APPEAL STATEMENT

Planning Inspectorate Reference:	APP/T2350/W/17/3178692
LPA Application Reference:	3/2017/0192
LPA Officer:	Stephen Kilmartin

Full planning consent for the change of use from former agricultural building to one dwelling

Countess Hey, Elmridge Lane, Chipping PR3 2NY

proposed ground floor layout - 1:100

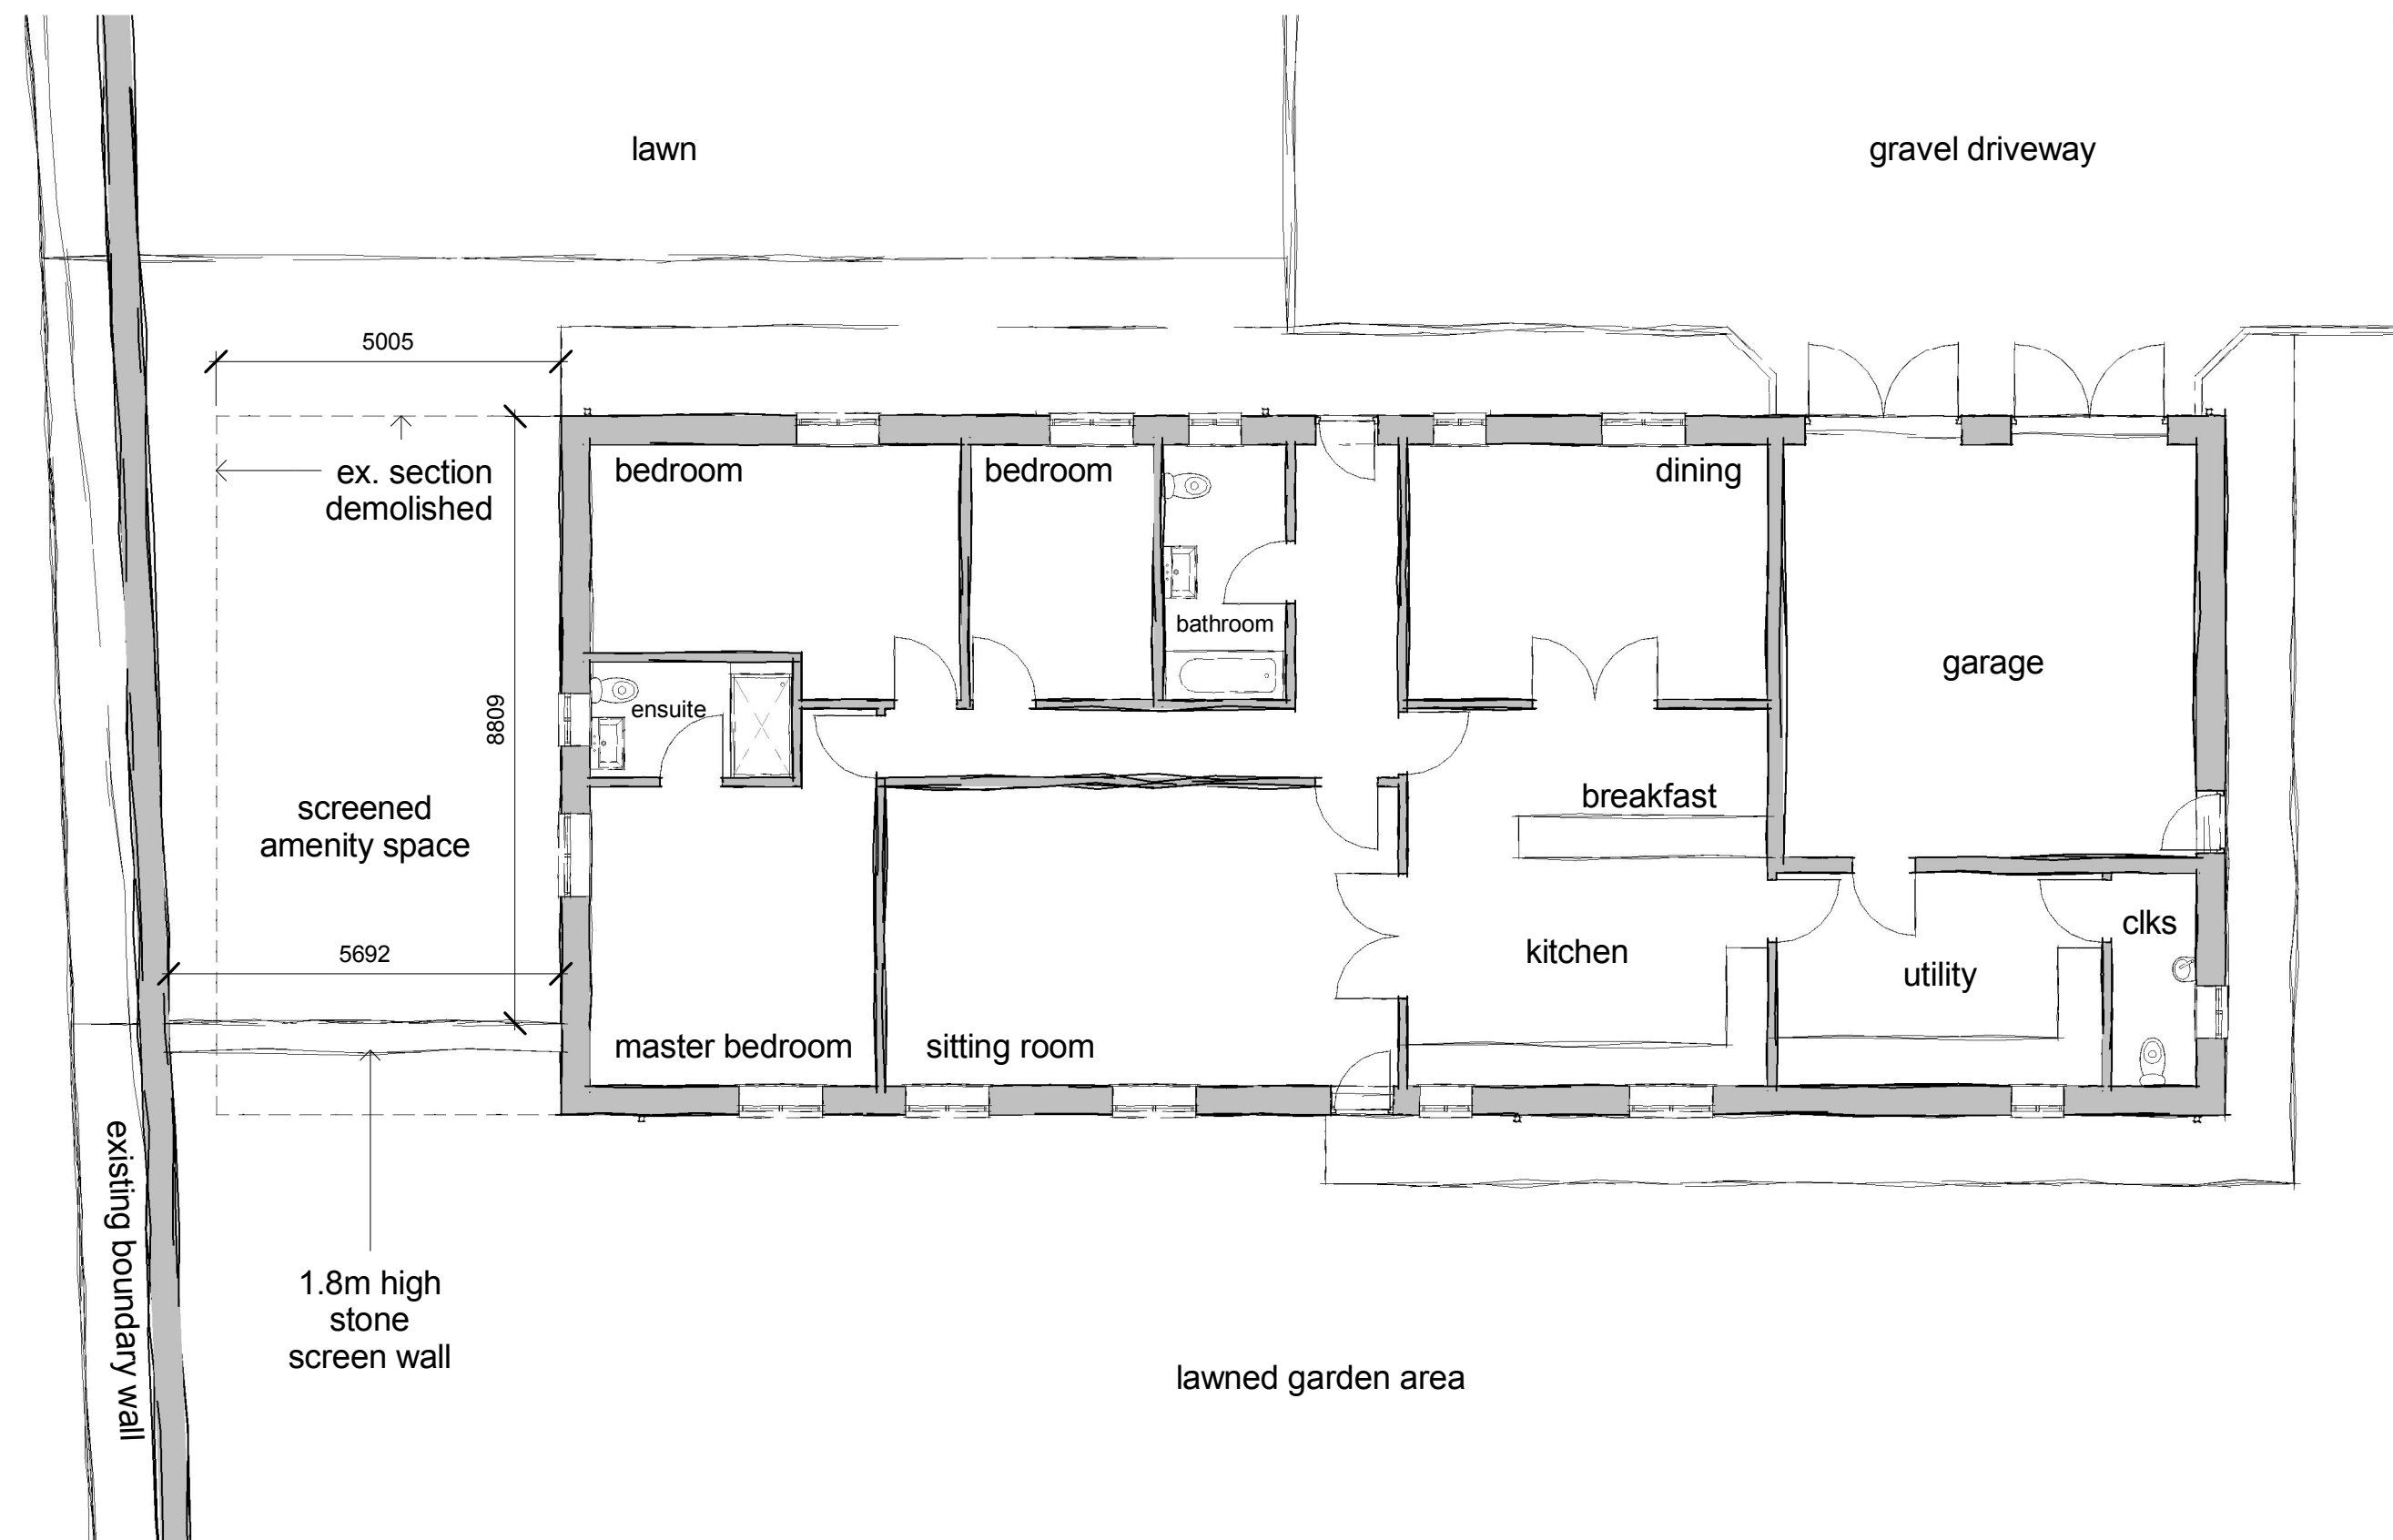
- 3.3** The existing building measures approximately 10.1m in width and being 29m in length resulting in an overall footprint of 292.9sq.m. The submitted details propose a reduction in the footprint of the building through the demolition of a western section of the building which measures approximately 5m by 10.1m (50.5sq.m) resulting in a footprint reduction of approximately 17.2%, contrary to the appellants claims that the footprint will be reduced by 21%.
- 3.4** The application site area measures approximately 1125sq.m in area, taking into account the footprint of the building post demolition work (242.4sq.m), this will result in the creation of an associated private residential garden area measuring approximately 882.6sq.m.

- Remove existing gable west elevation and demolish portion of building
- Re-cover existing roof with natural blue/grey slates
- Cladding of all external walls of the building in natural stone.
- North Elevation: Introduction of 5 window openings, one door opening and two garage door openings.
- South Elevation: Introduction of six windows openings and one door opening
- East Elevation: Introduction of one window opening and one door opening
- West Elevation: Introduction of two window openings.
- Creation of a residential curtilage (excluding the footprint of the dwelling) of 882.6sq.m
- Erection of boundary fencing/walling to demark proposed residential curtilage.
- Creation of vehicular access point to north of application site.

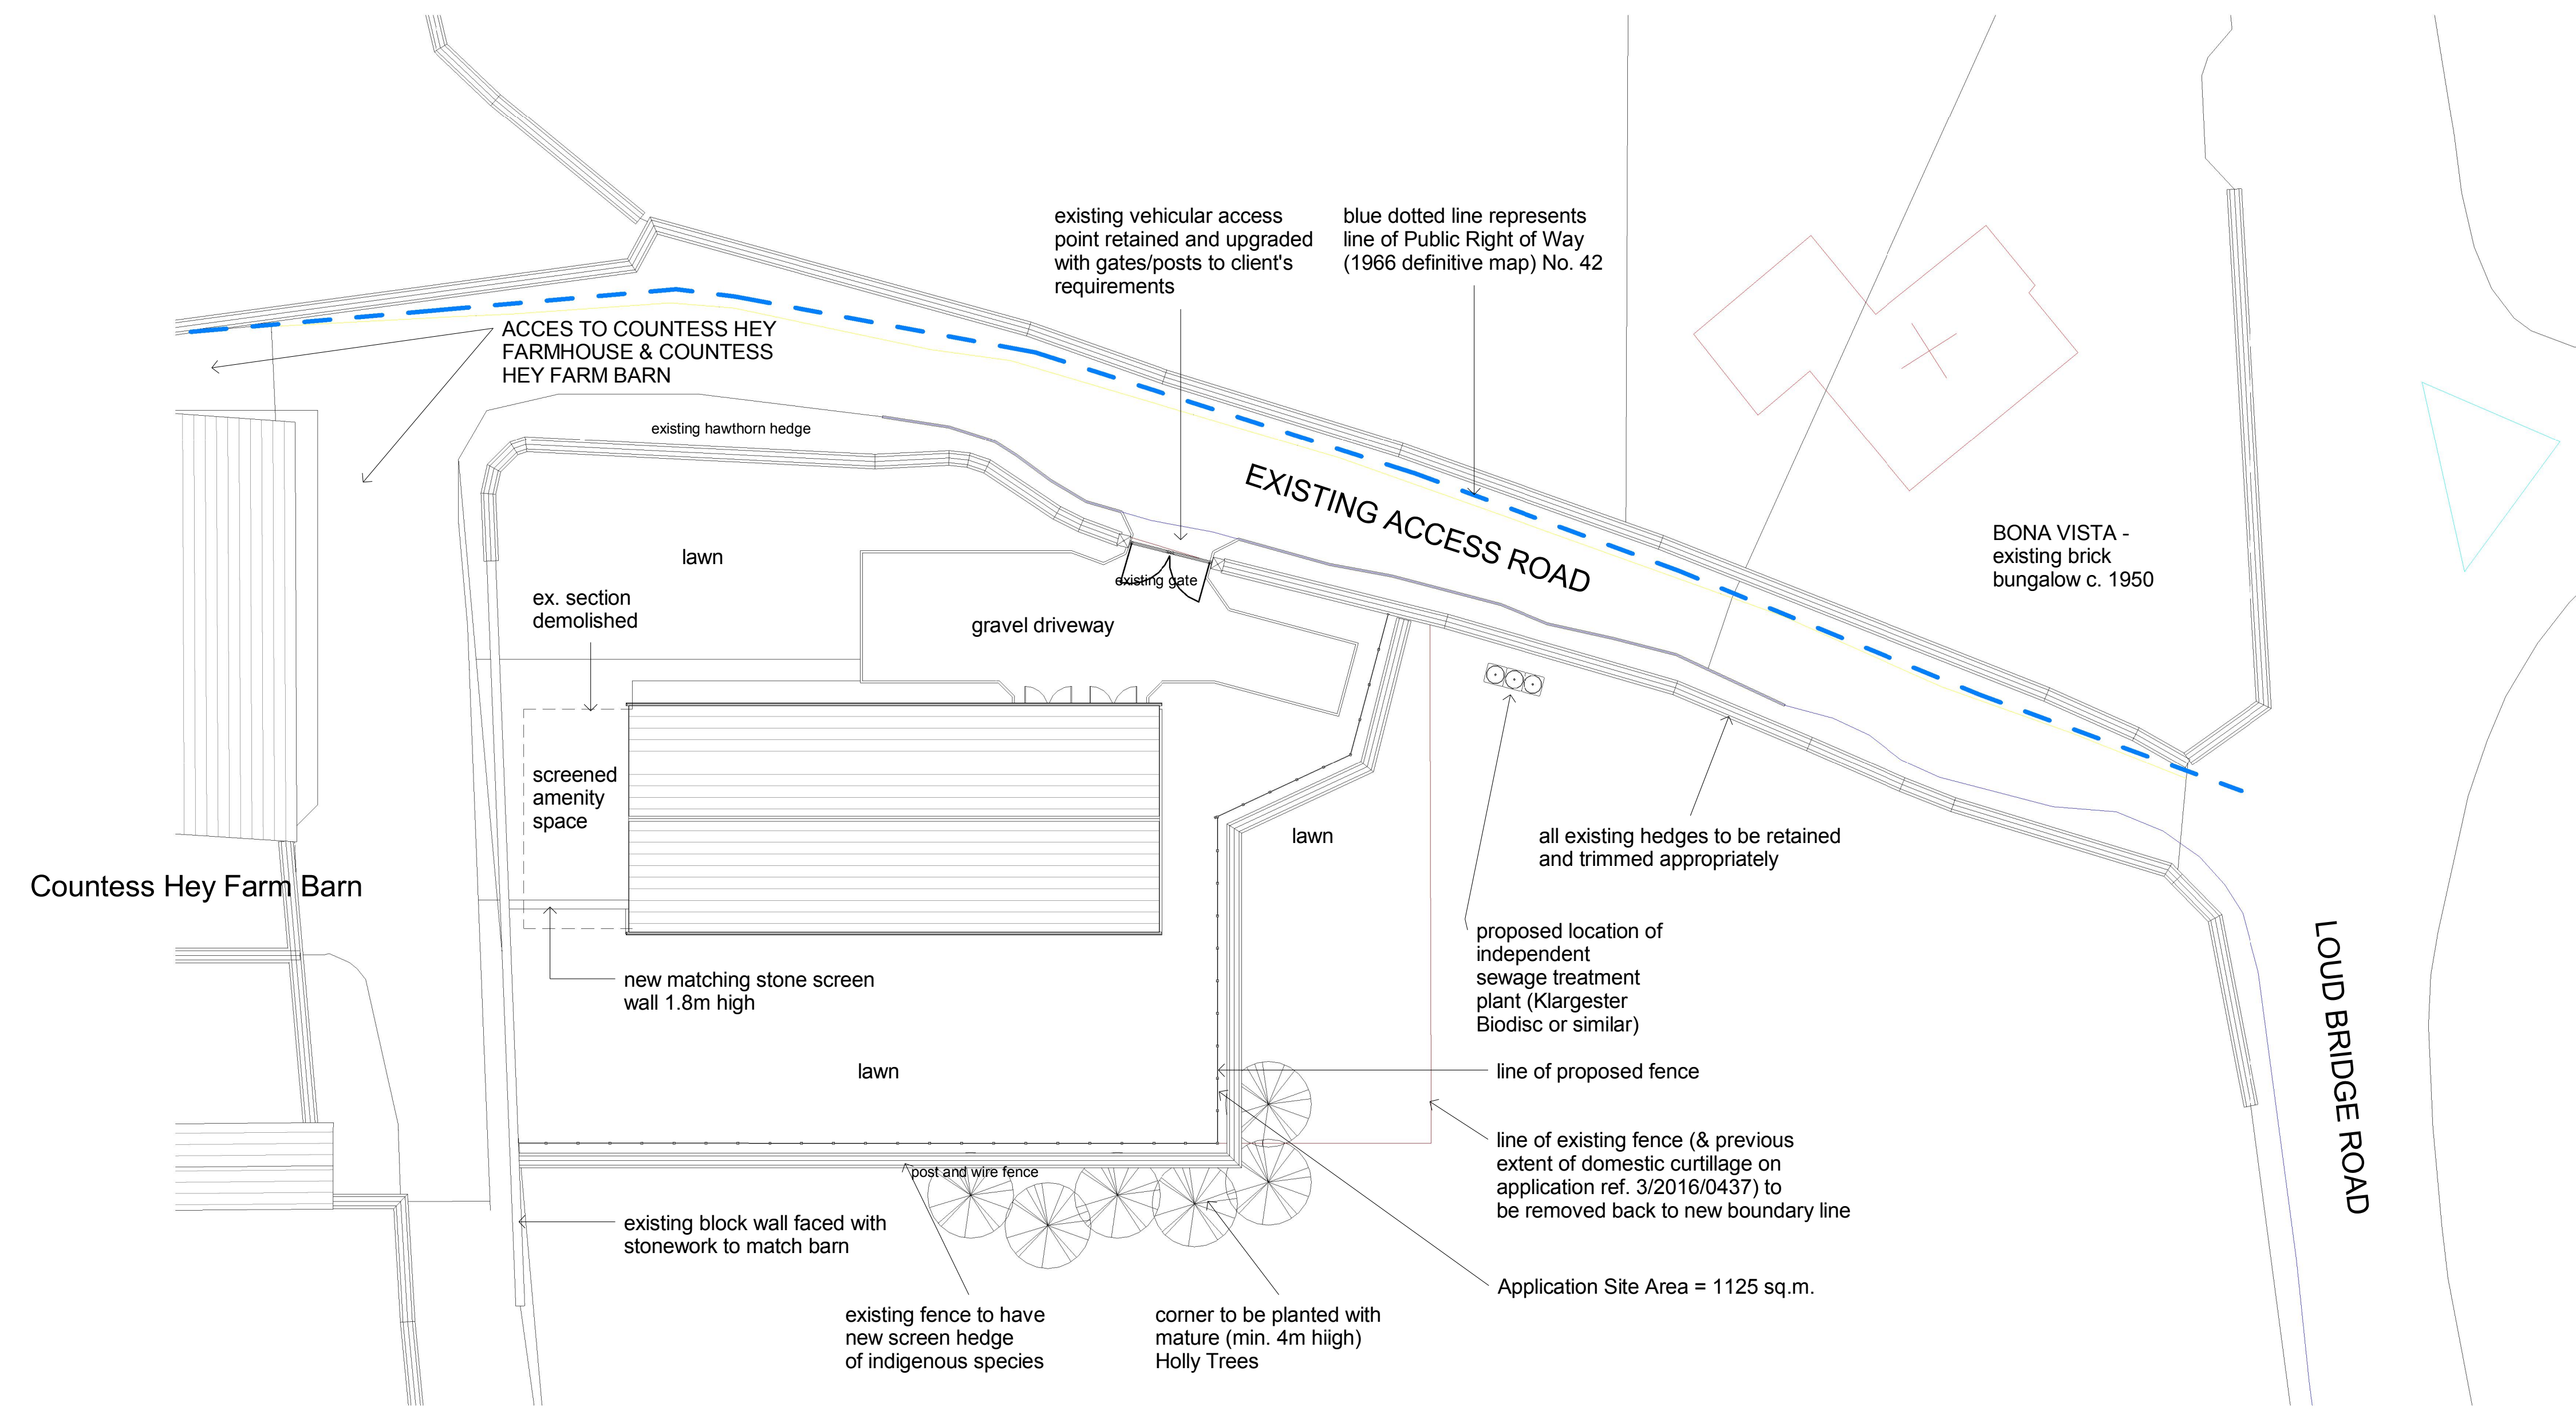
3. *The proposal, by virtue of the extent of proposed residential curtilage, driveway area and the likely visual impact of associated domestic paraphernalia such as sheds, washing lines, children's play equipment and fence lines would represent a suburban visual encroachment into the area to the detriment of the character, appearance and visual amenities of the area and the Forest of Bowland AONB contrary to Key Statement EN2 and Policies DMG1, DMG2 and DMH4 of the Ribble Valley Core Strategy*

- 9.8** Paragraph 5.30 of the appellants statement claims that the residential curtilage associated with the development is likely to be 'modest'. The Local Planning Authority disagrees with this point insofar that it is clear the curtilage associated with the proposed conversion is significant in size measuring approximately 882.6 Sqm. Policy DMH4 states that *'The impact of the development, including the creation of garden area and car parking facilities (or other additions) should not harm the appearance or function of the area in which it is situated'* . It is considered that extents of the residential curtilage proposed are likely to result in compounding the proposals domestic and suburban appearance. It is further consider that the likely proliferation of domestic paraphernalia within the proposed curtilage will be of further detriment to the protected landscape through the creation of a suburban visual encroachment into the area.
